**Exhibition of Proposed O'Connell Street Primary School, 24A O'Connell Street, Parramatta (SSD 7372)**

### Office of Environment and Heritage comments on exhibition of Proposed O'Connell Street Primary School at 24A O'Connell Street, Parramatta (SSD 7372)

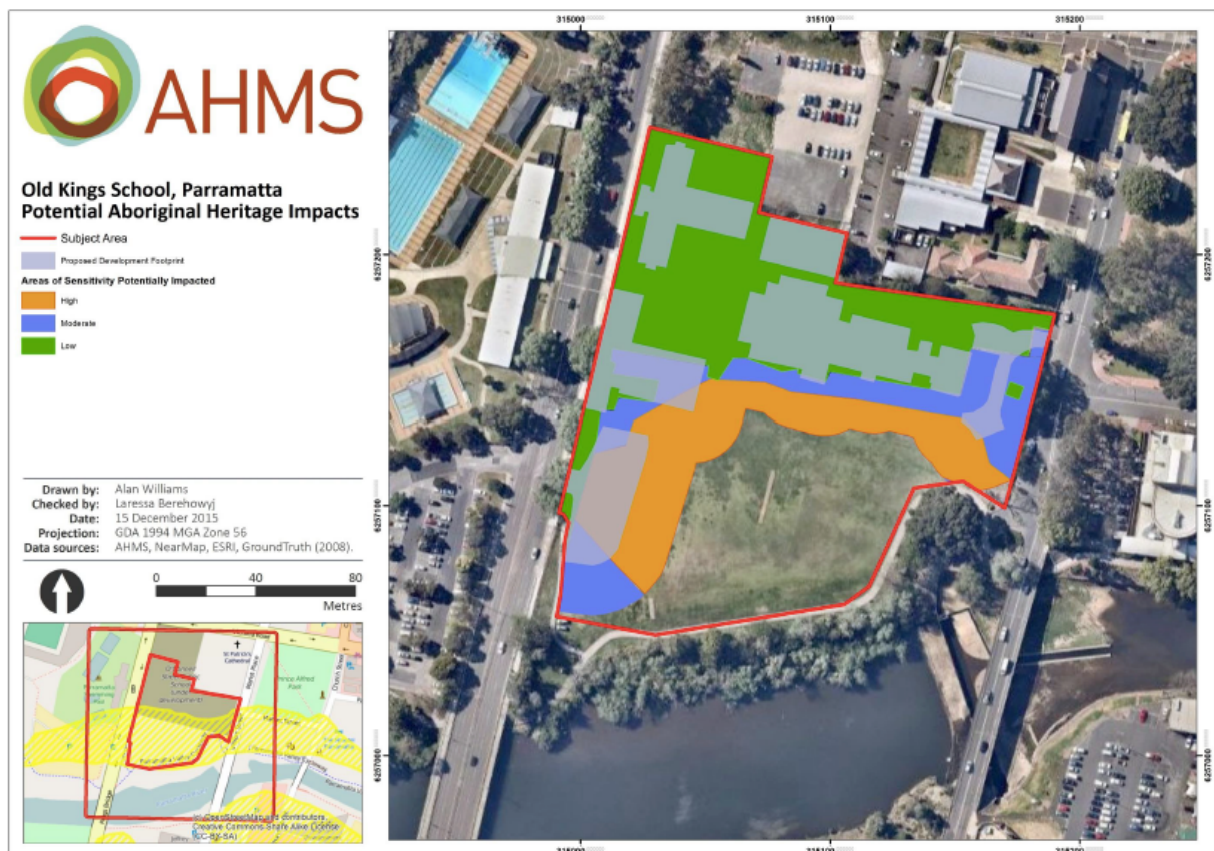
- The map at Figure 12 of the Report shows the extent of the Kings School PAD. Figure 13 shows the location of test pits, most of which are located outside the area of PAD. The reasons for this are not provided in the Report and it appears that the area where artefacts were recovered was subsequently identified as a site/included in the area of PAD. While OEH is aware that a recommendation has been made to re-name the Old Kings School PAD as Old Kings School AS1 and a new site card submitted to AHIMS, this does not appear to have happened to date. Section 89A of the *National Parks and Wildlife Act 1974* (NPW Act) requires that all objects should be recorded within a reasonable timeframe. OEH recommends that the site card is submitted as soon as practicable.

- An assessment of the potential impacts of the proposed development has not been articulated in the Report. Similarly with future infrastructure works and their impacts. A discussion of the consequence of these impacts on the significance of what has been found on site has not been included.

- OEH notes that a very limited program of archaeological salvage has been proposed. It is unclear why it is so limited for such a potentially significant area. It is also unclear why retention in situ has not been proposed.
